Ashfield Council

20 May 2013

Stage 1 Project Application 2-32 Smith St Summer Hill

At its meeting on 14 May 2013, Council resolved as follows:

SCHEDULE OF LOTS & NOTATIONS

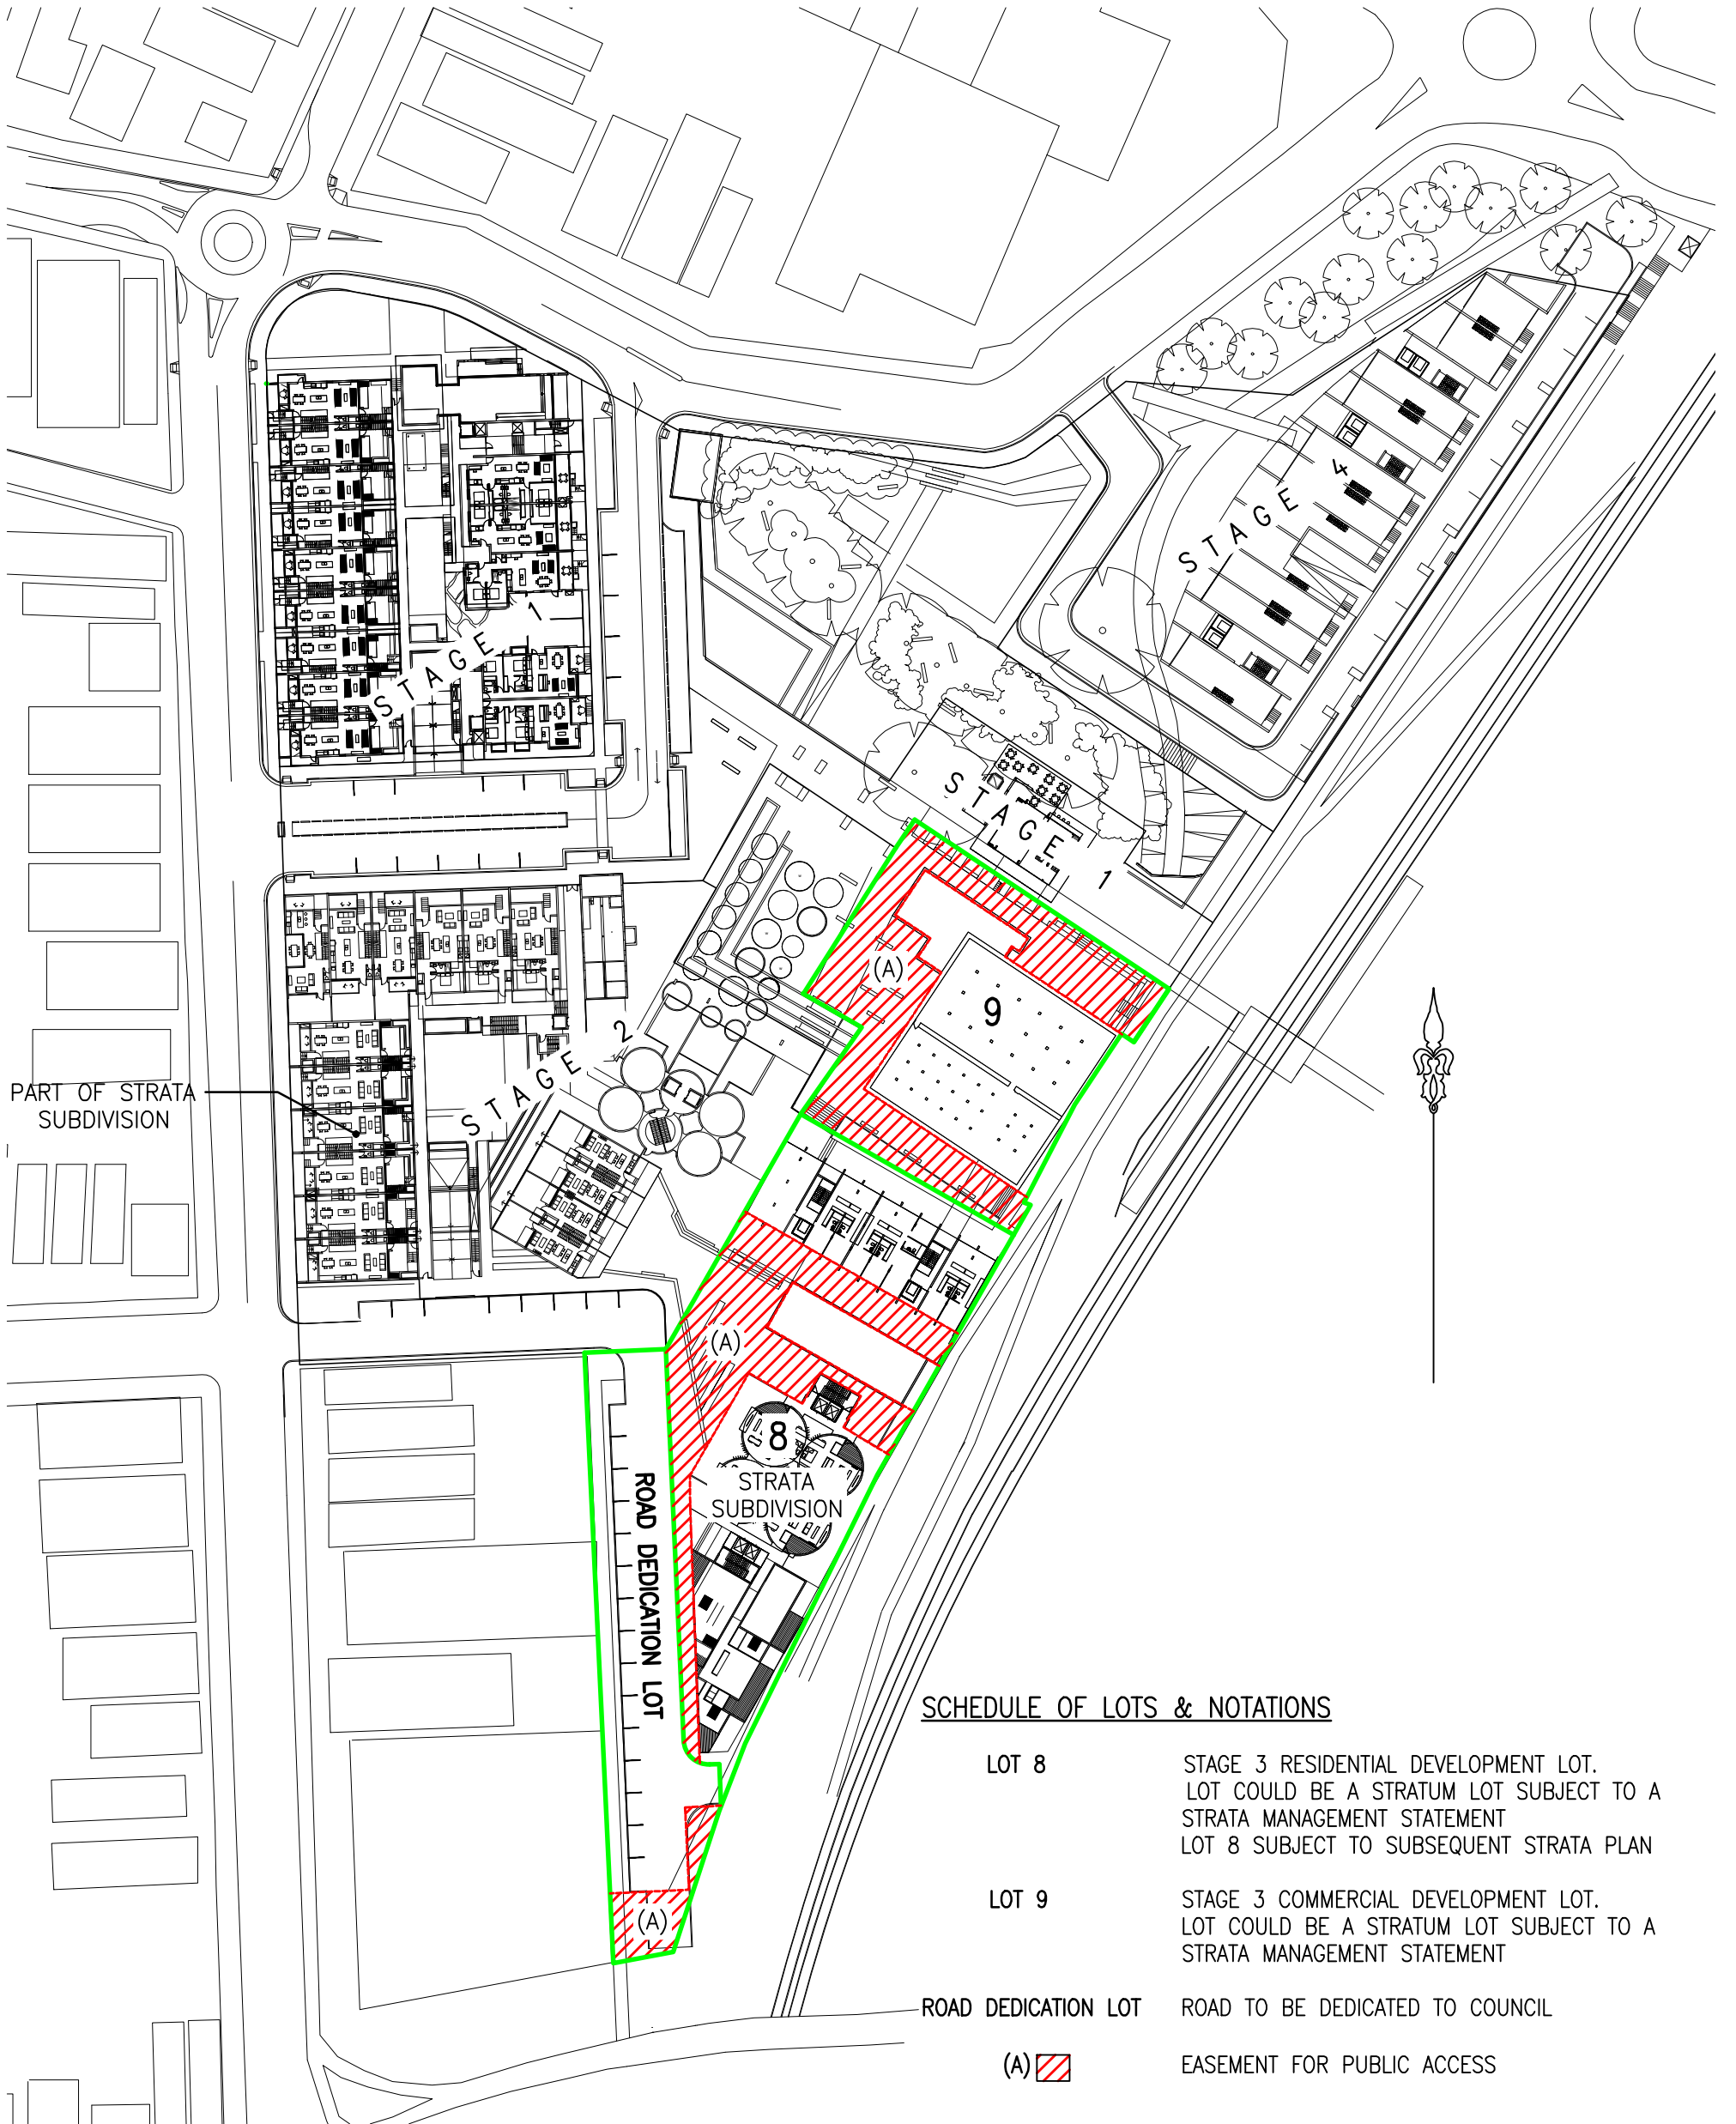
- 1) That pursuant to the 'Concept Approval' conditions no 23, 24, 25 and 26 requirements are placed on the land title of new allotments to ensure that the following occurs:
- (i) Publicly accessible open space is provided for the relevant allotments, including the 'Portion 4' allotment which on the approved Concept Plan is described as open space.
- (ii) That the pedestrian public access way to the proposed Light Rail station from the internal street to the boundary with the Railways land and Light Rail station, which is proposed to be dedicated to Council and shown on the subdivision plans, have a minimum width of 8m, as shown on the approved Concept Plan drawings.
